## **Additional Comments on Deadline 1 Submissions**

## **DRAFT Development Consent Order [REP1-008]**

### **Chapter 8: Traffic and Transport [REP1-018]**

**Traffic and Transport Baseline Report Part 1 [REP1-027]**

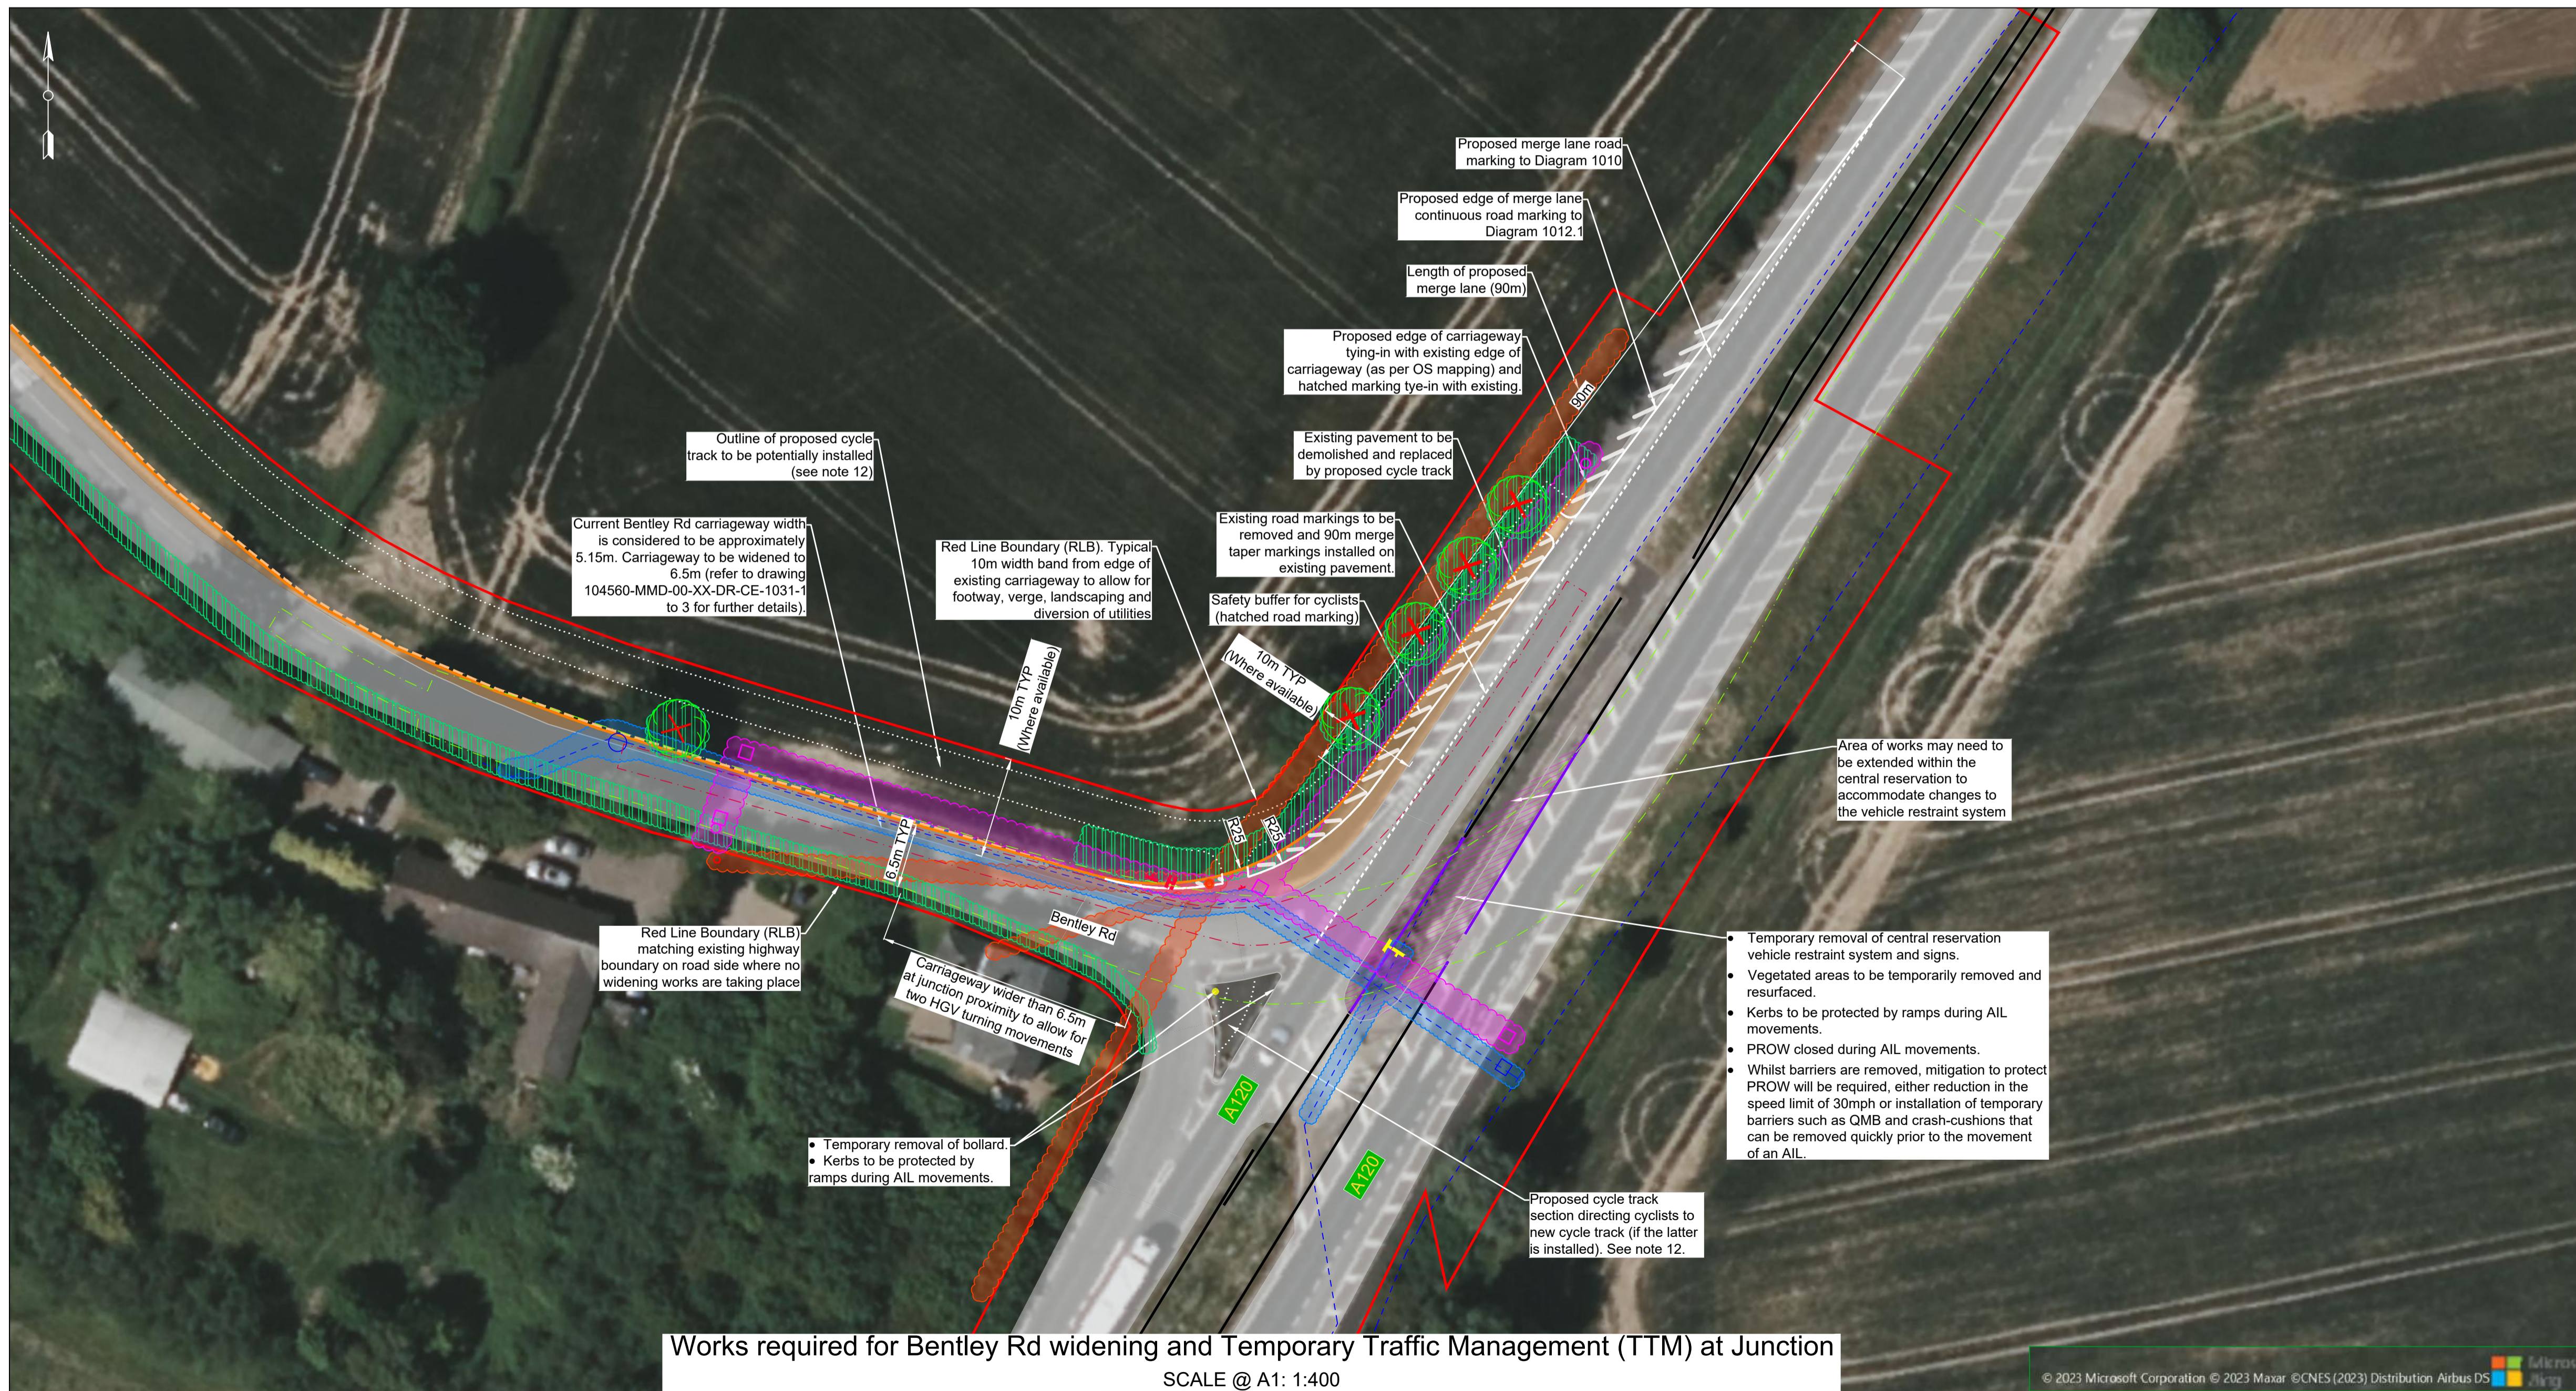
Change	Description
Appendix W 'Section 4 Traffic Management'	<p>Under section 4 Traffic Management it highlights a requirement to close Bentley Road to undertake the widening works and it refers to a diversion route highlighted below:</p> <p style="text-align: center;"><b>4 Traffic Management</b></p> <p style="text-align: center;"><small>The junction improvements will require traffic management during the installation. This section of the assessment identifies the likely traffic management requirements and their potential impacts.</small></p> <p style="text-align: center;"><small>To complete the widening works along Bentley Road the road will need to be closed to traffic, although access to residences would need to be retained for the duration. A diversion along Payne's Lane, Hilliards Road and Park Road will be needed, this is approximately a 4km diversion.</small></p> <p>However, only the northern section of Payne's Lane is adopted the rest is a single lane private farm track. The only alternative is to use Church Road, Spratt's Lane, Hilliards Road and Park Road.</p>

**Co-located Substation Early Design
A120 - Bentley Road Junction
Swept Path Analysis
"contra-flow" Option
Sheet 01 of 01**

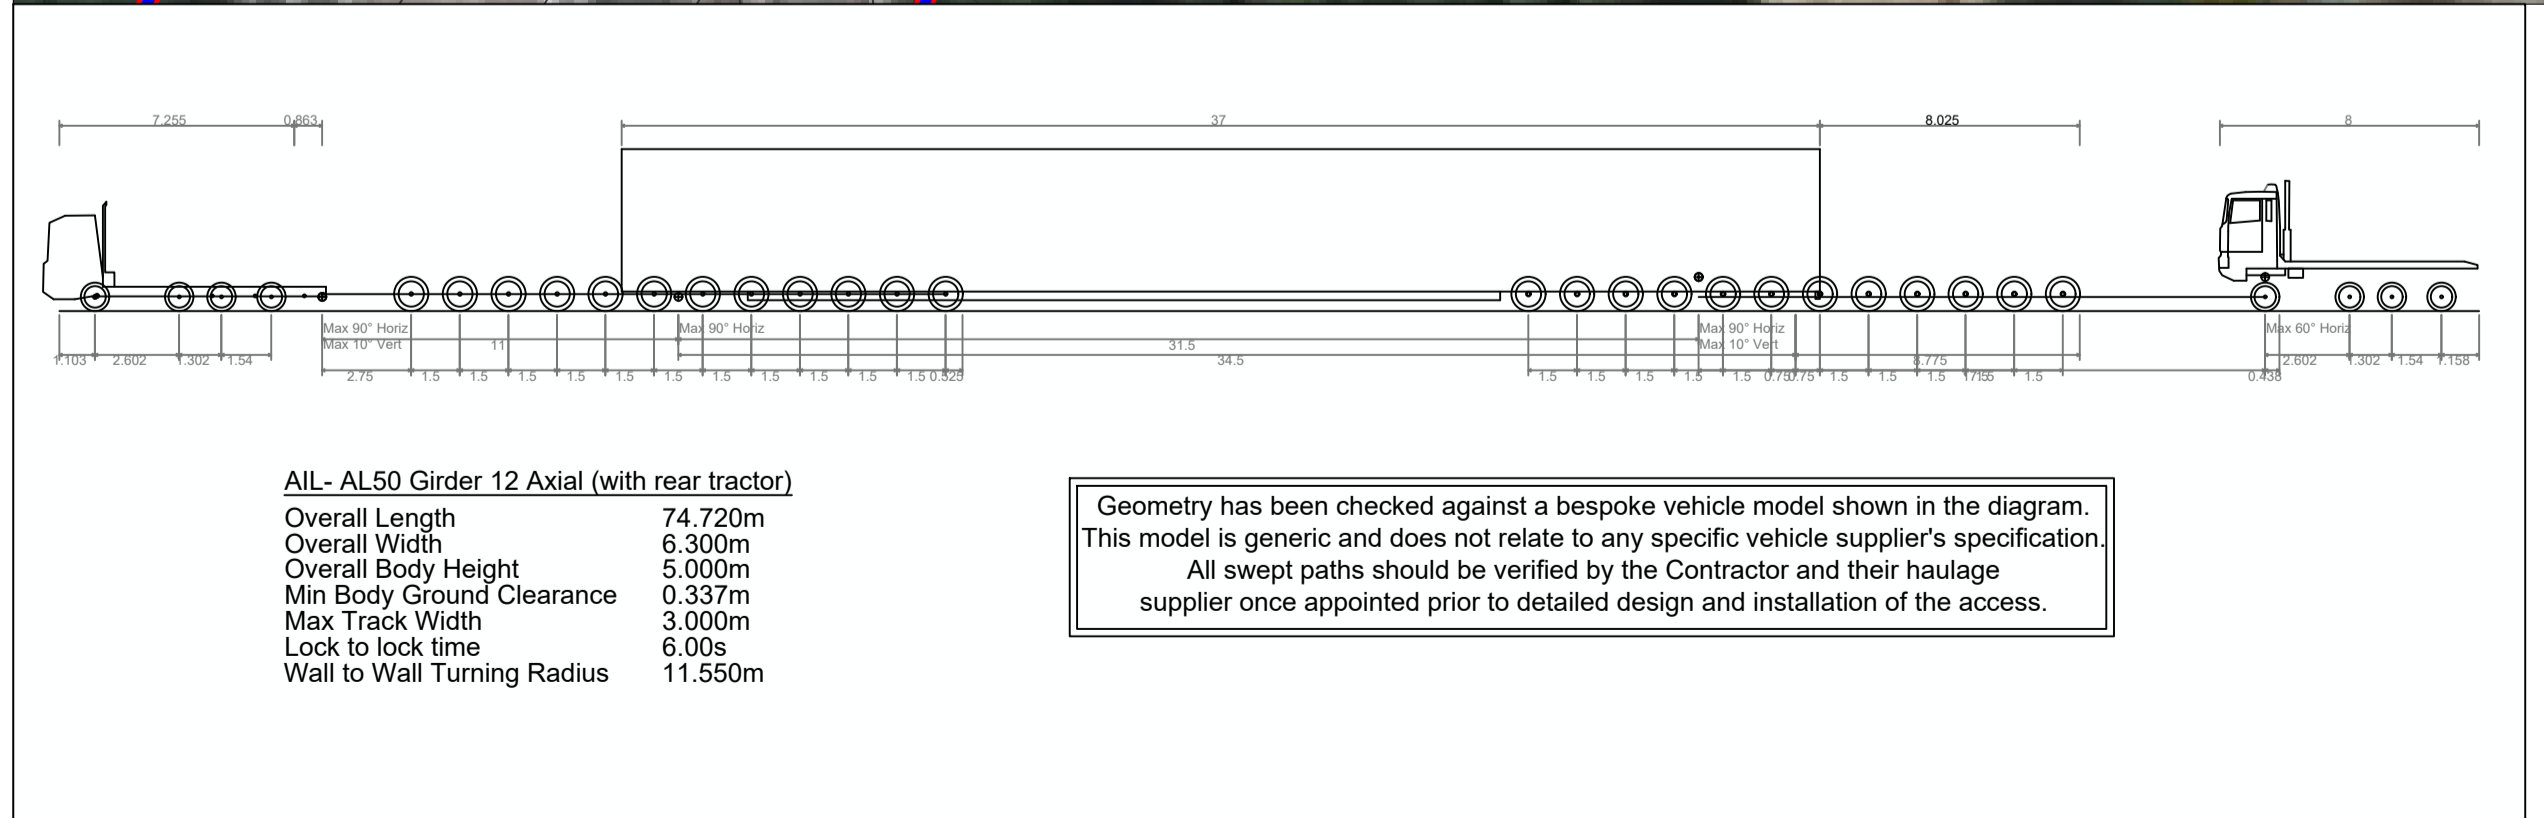
Appendix Y 'Abnormal Indivisible Load Investigations'	<p>The swept path for the abnormal load only shows a vehicle travelling in a single direction. It is unclear what the arrangements are here for the movement. Appendix W Section 3.1 refers to Drawing 104560-MMD-00XX-DR-CE1026, but the swept path provided at Appendix Y is a different drawing. Clarity should be provided on the swept path for AILs at Bentley Road.</p>

4.1.12	Refers to the AIL route investigations and swept path drawings at Appendix Y of the Transport Assessment, as above further clarity is sought on the arrangement being proposed here.
